Application Ref:	3/2025/0580	 Ribble Valley Borough Council www.ribblevalley.gov.uk
Date Inspected:	06/08/25	
Officer:	KH	
DELEGATED ITEM FILE REPORT:		Decision Approval

Development Description:	Full planning permission for conversion of barn into two dwellings. Alterations to access and construction of detached triple garage. Creation of new vehicle access to farmhouse and construction of attached double garage.
Site Address/Location:	Holmes Farm, Higher Commons Lane, Balderstone BB12 7LR

PROPOSED SOUTH EAST ELEVATION (1)

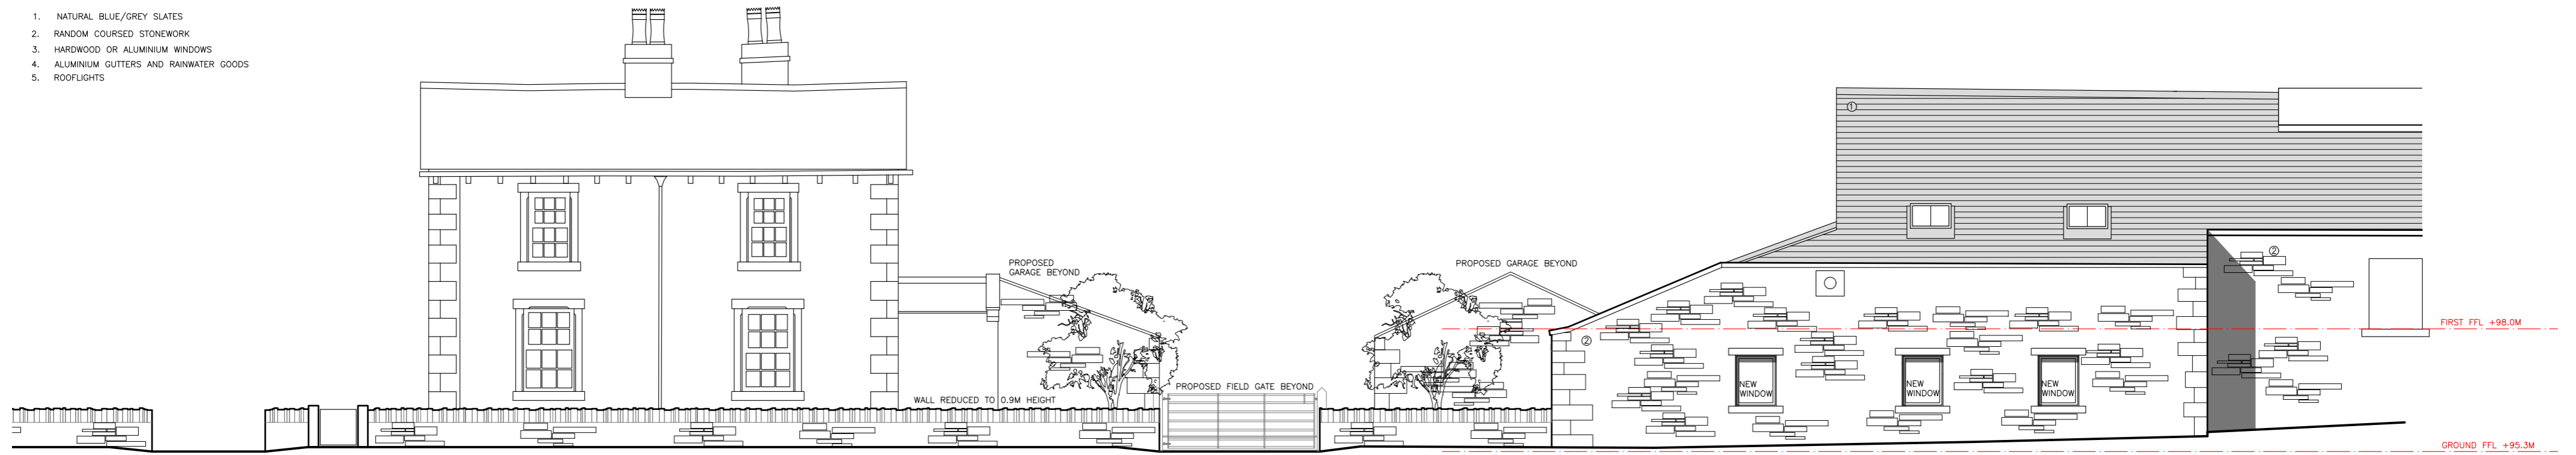
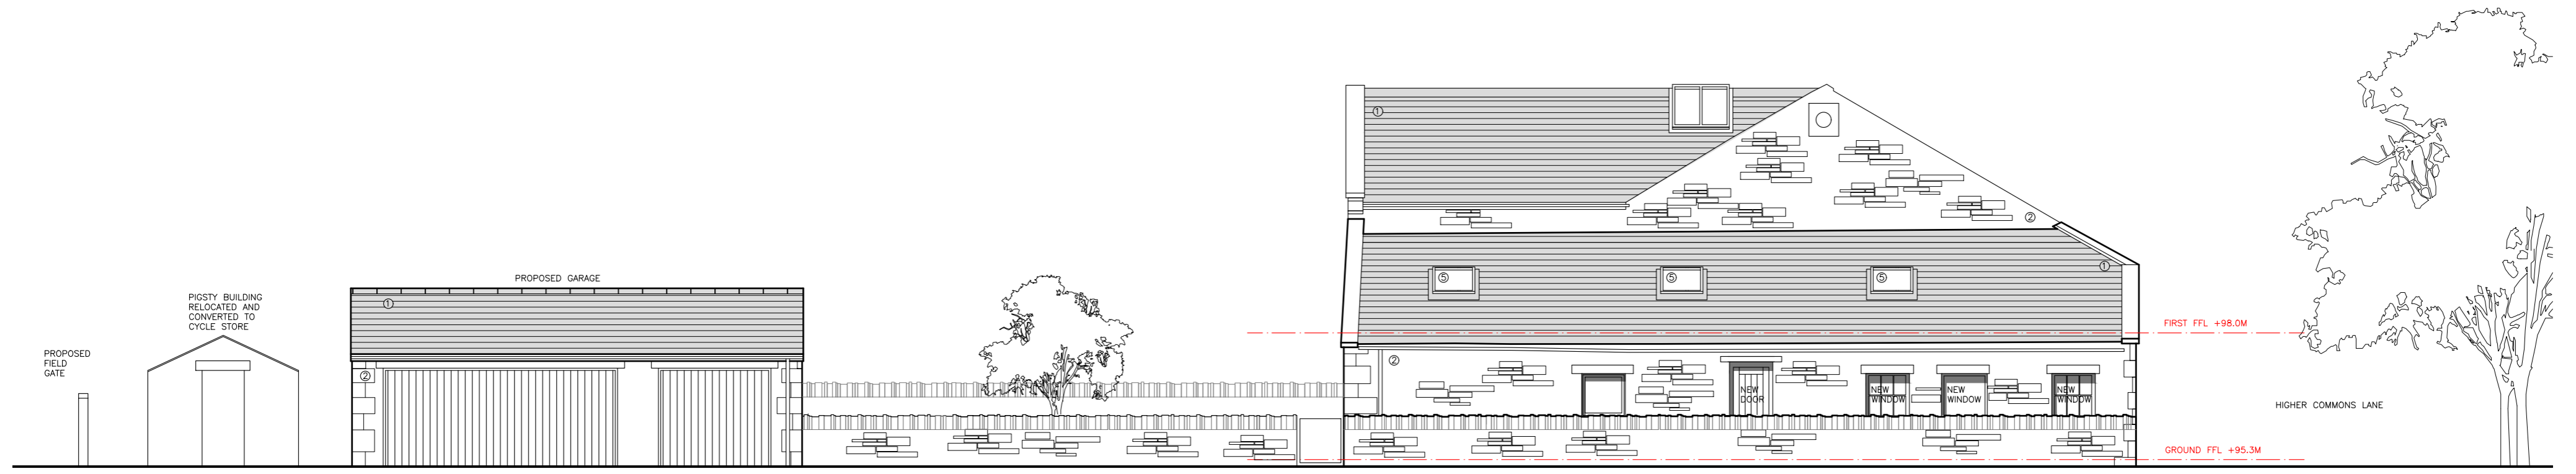
We note that there are plans to create new openings in the side of the barn facing the road. When we carried out our conversion some years ago this was not permitted.

Amended plans have been received which remove the proposed windows to the southeast frontage. With the additional openings proposed restricted to the rear (northwest) and side (southwest) elevations, these would not unduly impact on the character and would not result in removal of historic fabric.

PROPOSED NORTH EAST ELEVATION (4)

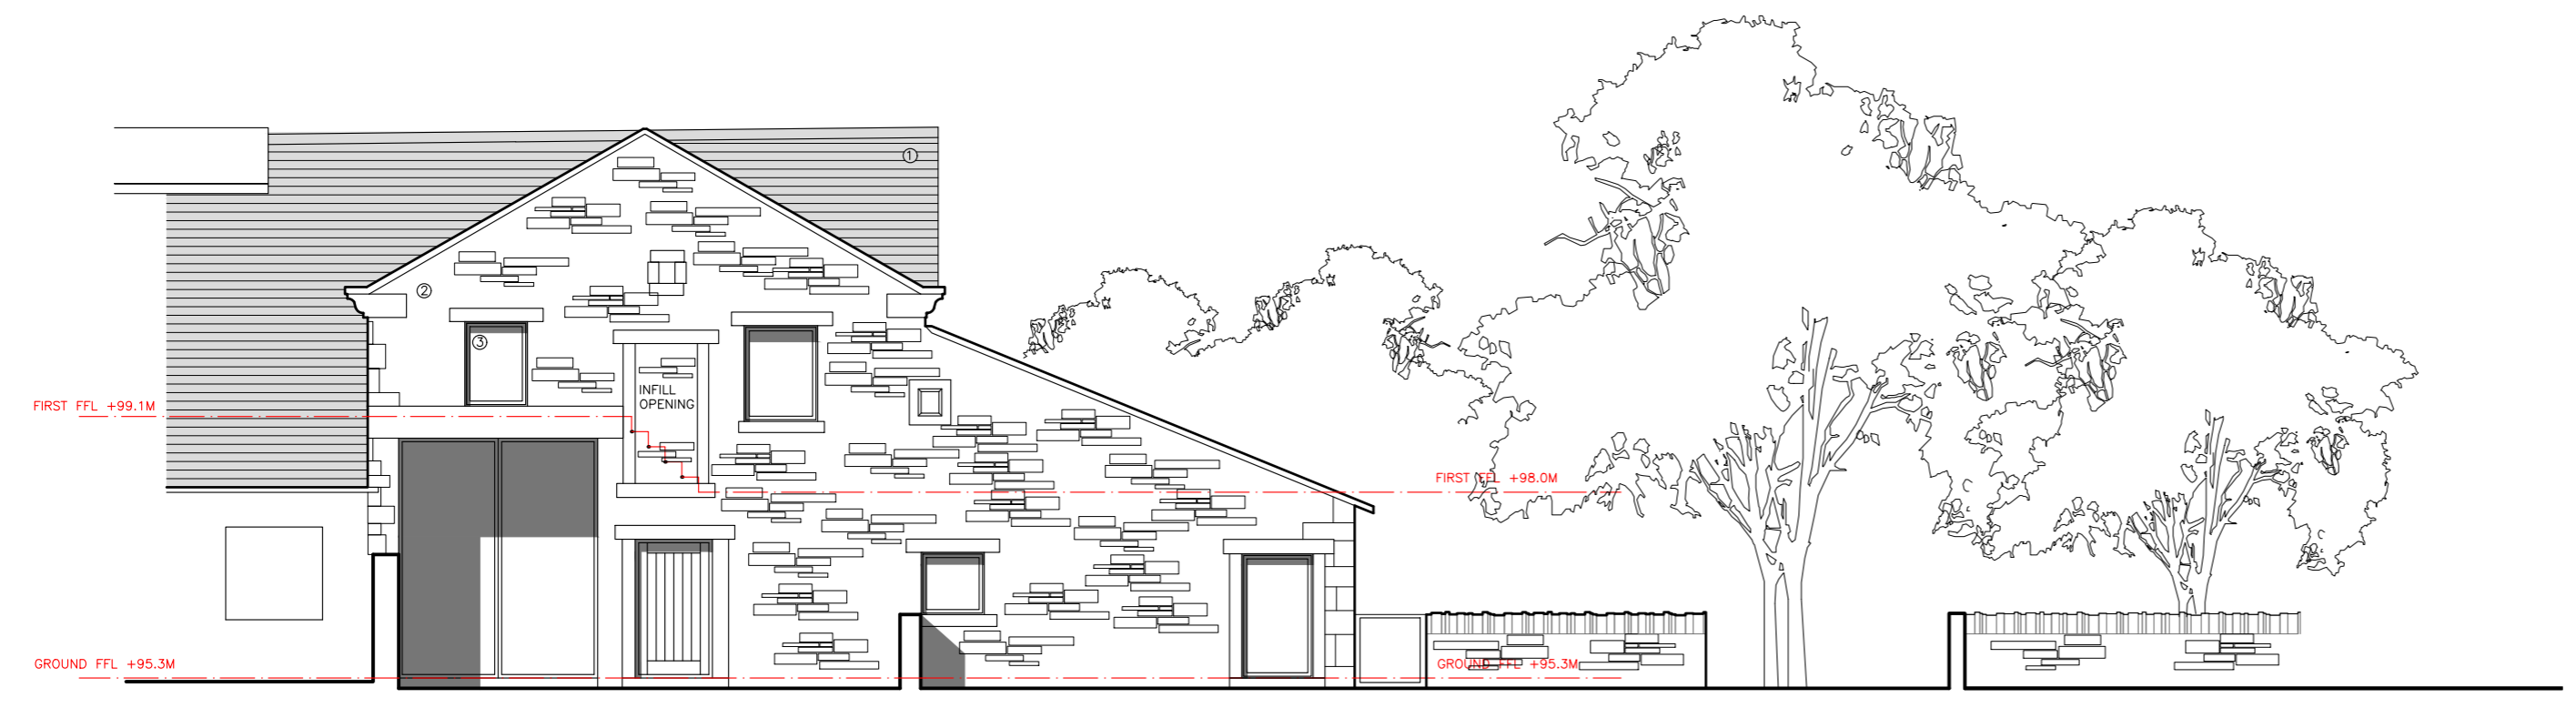
The site adjoins Holmes Cottage to its eastern side and therefore care needs to be given to the positioning of additional windows particularly the side projection (northeast) elevation as this faces into the cottage garden. The existing window at ground floor to the side (northeast) elevation would serve a utility room and be obscure glazed which is acceptable.

There is an existing opening to the northeast elevation which overlooks the adjacent garden of the adjoining conversion. It is proposed that this window would serve a utility room, however, it would be appropriate to ensure this opening is obscurely glazed in order to avoid any undue loss of privacy.

PROPOSED GARAGE 2 FRONT ELEVATION (6)

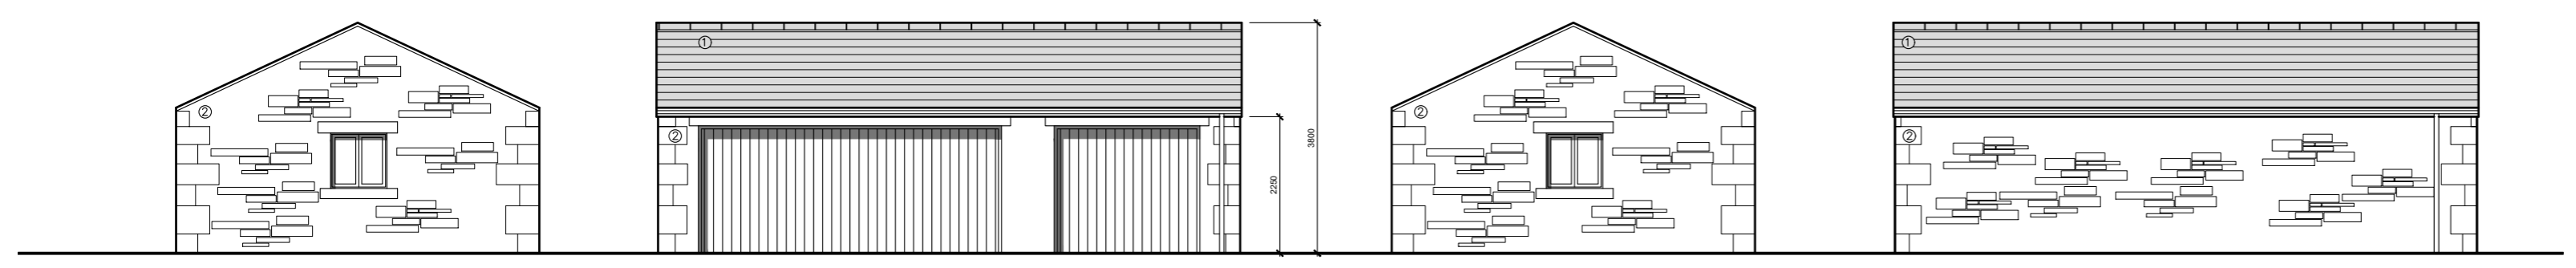
One response received raising concerns with the three-garage unit and its location 1m from the property line which may result in shadow from the building at different times of the year. The location and the height might be significant; placement of the building more than 1m away, or a reduction in the ridge height may ameliorate this issue. In addition a distance of 1m between the building and property line will make it hard to manage that side of any hedge/shrubs /trees.

Concerns have been raised by third party about the scale of the detached garage. Amended plans show this has been reduced and the proposed scale and siting do not raise any concerns with respect to overbearing impacts or loss of light.
